An
Bord
Pleanála

Board Direction
BD-009697-21
ABP-311302-21

The submissions on this file and the Inspector's report were considered at a Board meeting held on 20/12/2021.

The Board decided to grant permission generally in accordance with the Inspector's recommendation, for the following reasons and considerations, and subject to the following conditions.

Figure 4.1: Separation Distances Proposed with Large Setbacks from Block C and 3 No. Storey Duplexes and Apartments in Block E Highlighted

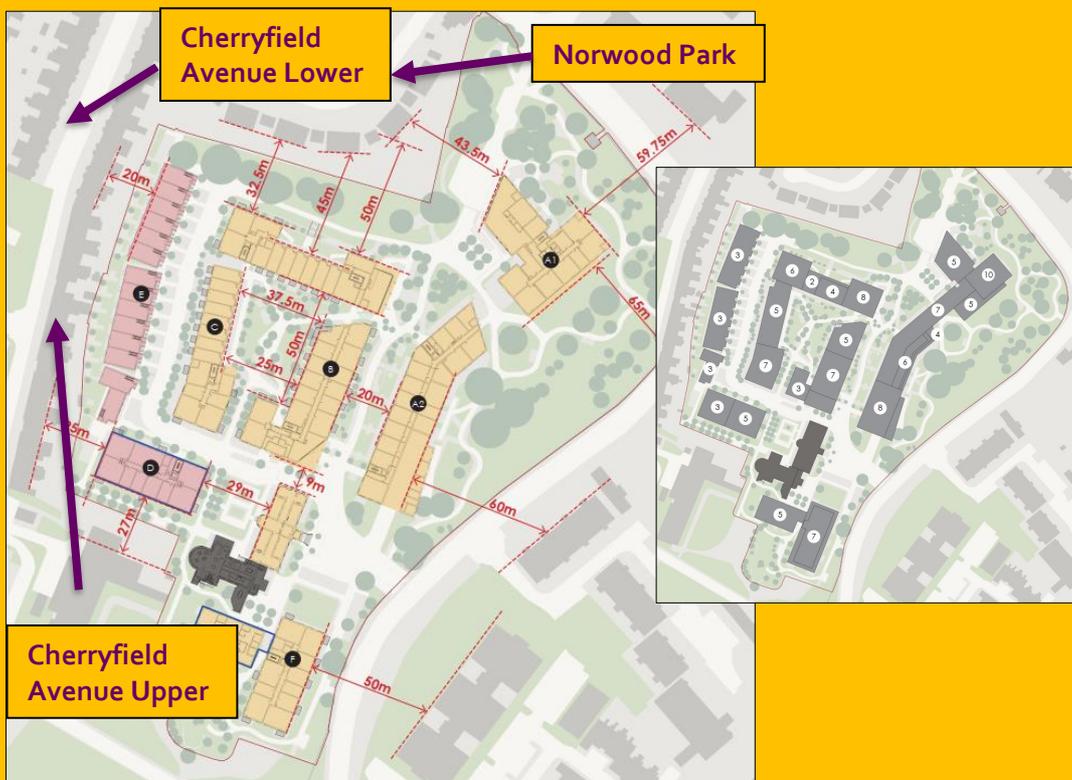
(a) The omission of the standalone duplex apartment block that comprises four units at the southern section of Block E (units BE.0001, BE.0002, BE.0201 and BE.0101) and their replacement with open space or for a use to be determined by a future planning application.

(b) The omission of the Bin and Bike Store buildings located to the north and south of Block E (two structures in total) and the relocation of these facilities to the basement level of Block B and C. The space vacated by the Bin and Bike Store buildings shall be replaced with open space.

(c) Units BE.G206 and BE.0113 shall be reconfigured to address and face across the new area of open space to the north of Block E as a consequence of (b) above. This will require internal modifications and a revised fenestration to the northern elevation.
